Recommendation Report for Planning Permission for Works or Extension to a Dwelling

REF NO: A/63/21/HH

LOCATION: 16 Woodlands Close
Angmering
BN16 4NA

PROPOSAL: Single storey side extension. This is a resubmission, with minor amendments, to approved application A/156/20/HH.

20064-512⁰

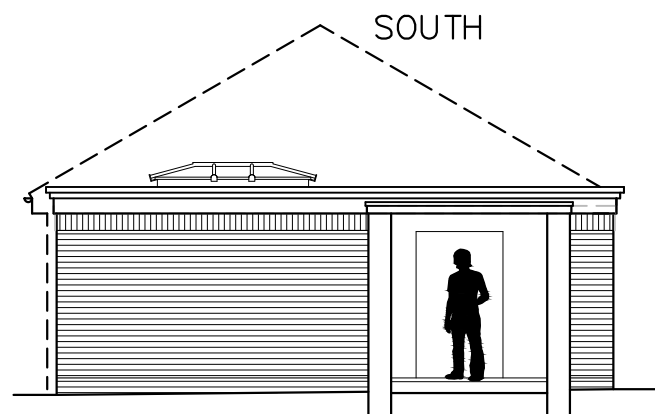
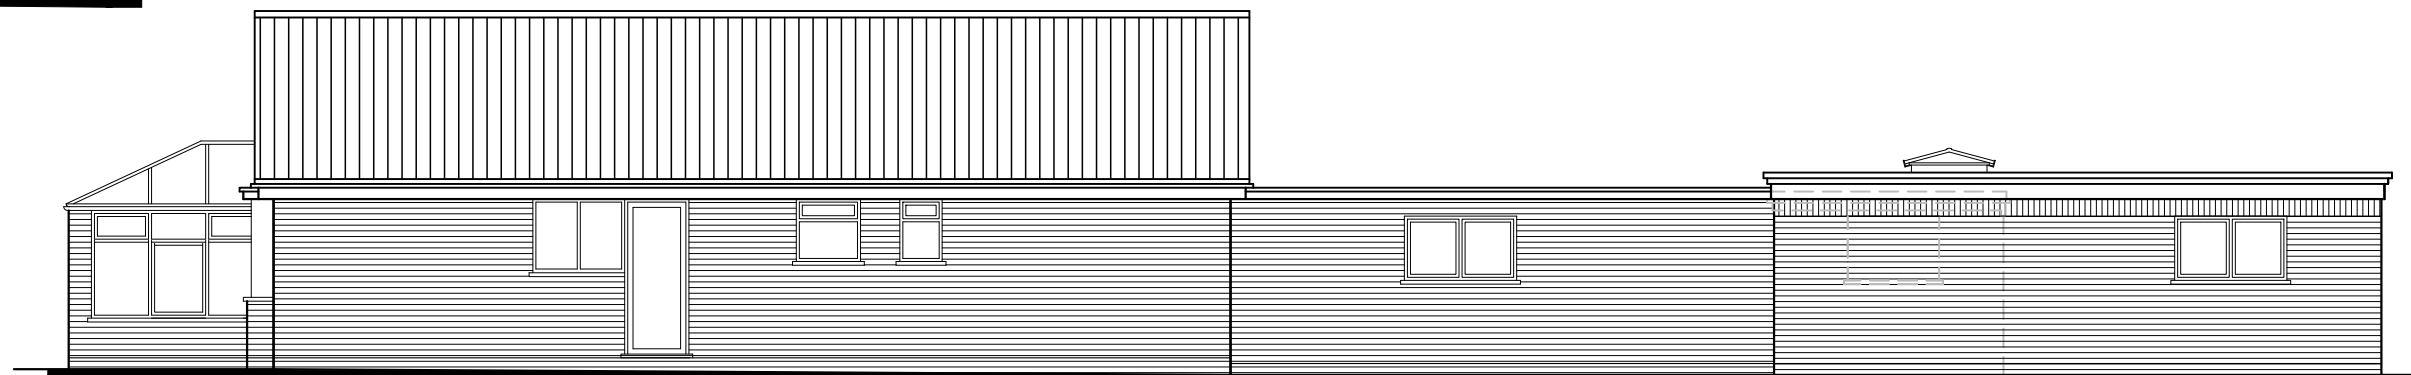
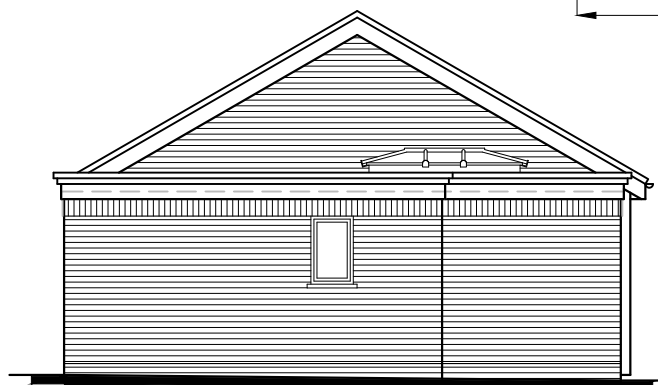
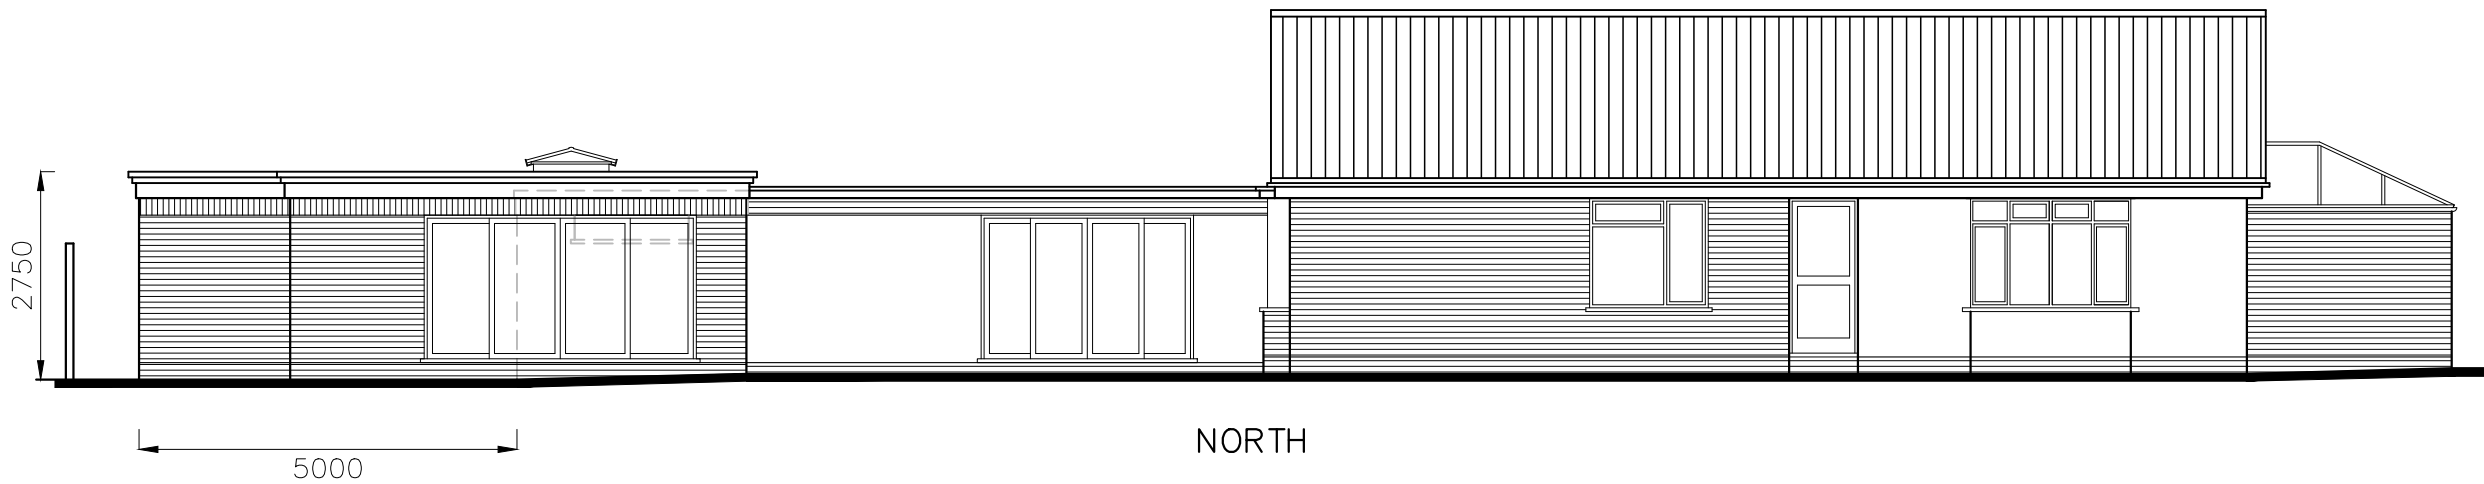
Various alterations to the fenestration have been proposed. It is proposed to remove the door and a

window from the eastern elevations and reposition the window within the extension to the southern elevation, a roof lantern has been proposed. As all windows are proposed to the ground floor and no concerns relating to overlooking have been raised.

In terms of overlooking, the proposed alterations to the approved extension are deemed to accord with Policies D DM4 of the Arun Local Plan and Part M of the Arun Design Guide.
